Yarnton Parish Council

Cherwell District Council
Planning Department

2nd October 2023.

COMMENTS ON PR8 OUTLINE PLANING APPLICATION 0 23/02098/OUT

Figure 14.3: Extent of surface water flooding

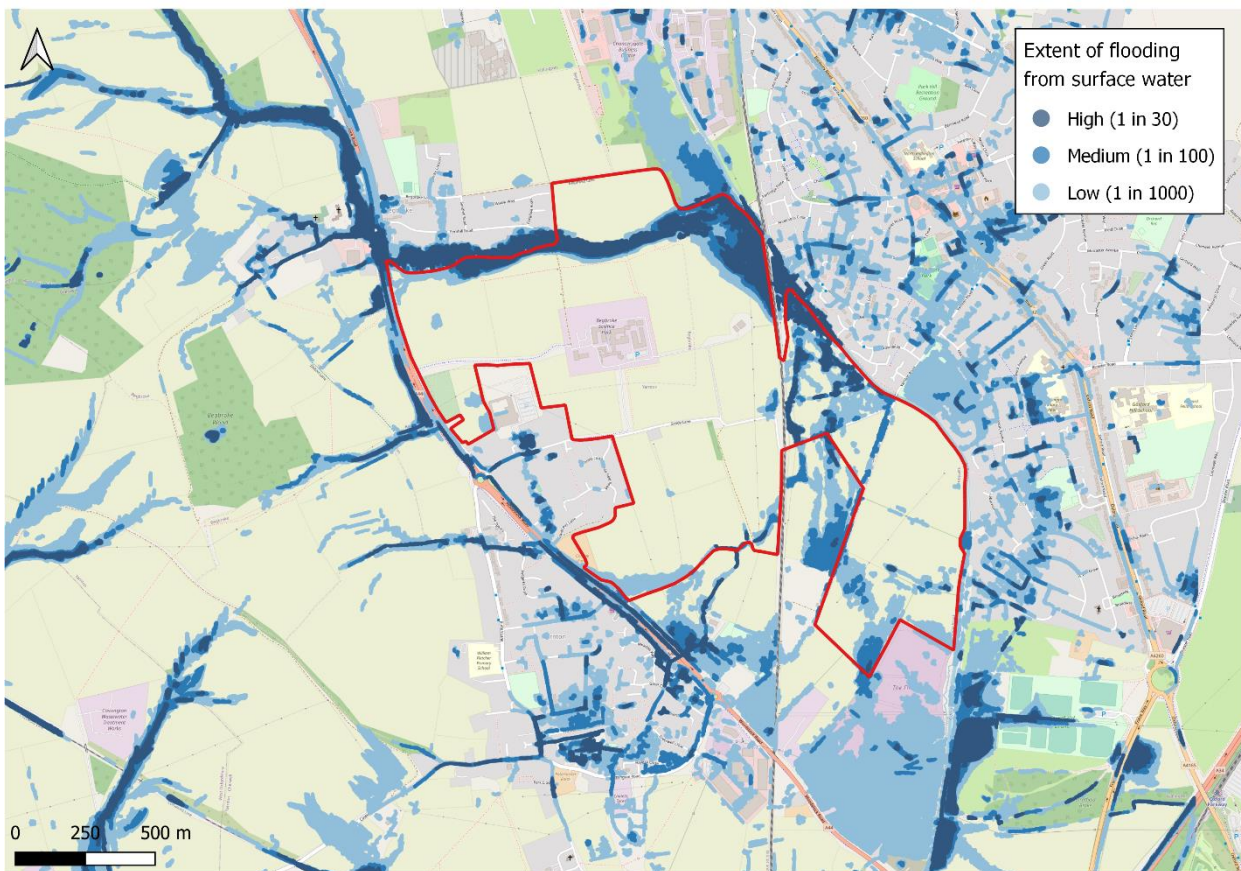
The report plans don't show all areas at risk of flash or groundwater flooding. In particular the area abutting the railway line which was flooded winter 2022.

**Figure 1 – Location Plan**

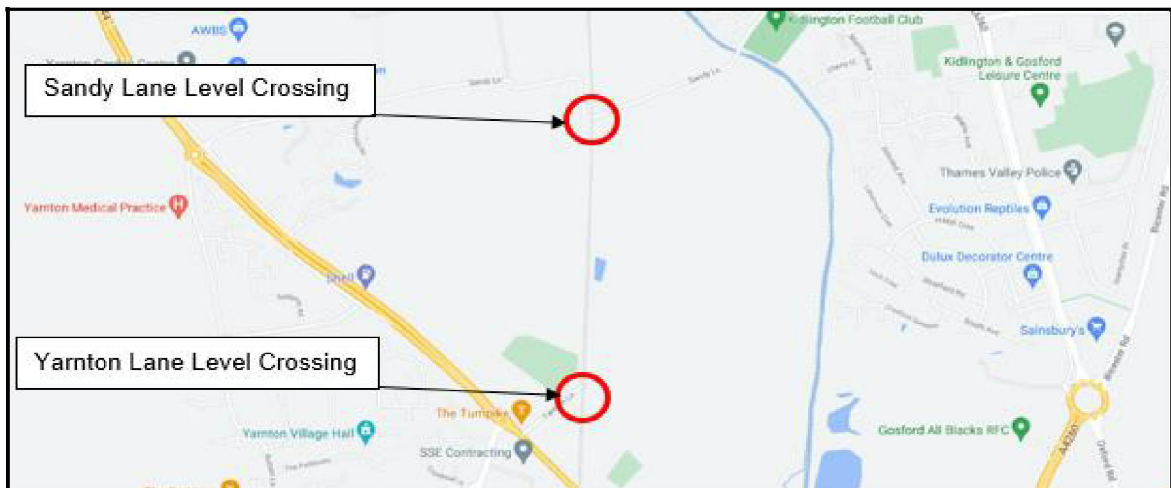
The development master plan shows safeguarded land for a new bridge over the existing rail line. But there seems to be no direct replacement for the existing well used link to Kidlington. Its intention seems principally to provide a link to land that can be developed at PR7.6. It is unclear how Sandy Lane, or the stub of it after closure, will link up with the rest of the development; is there no connection?
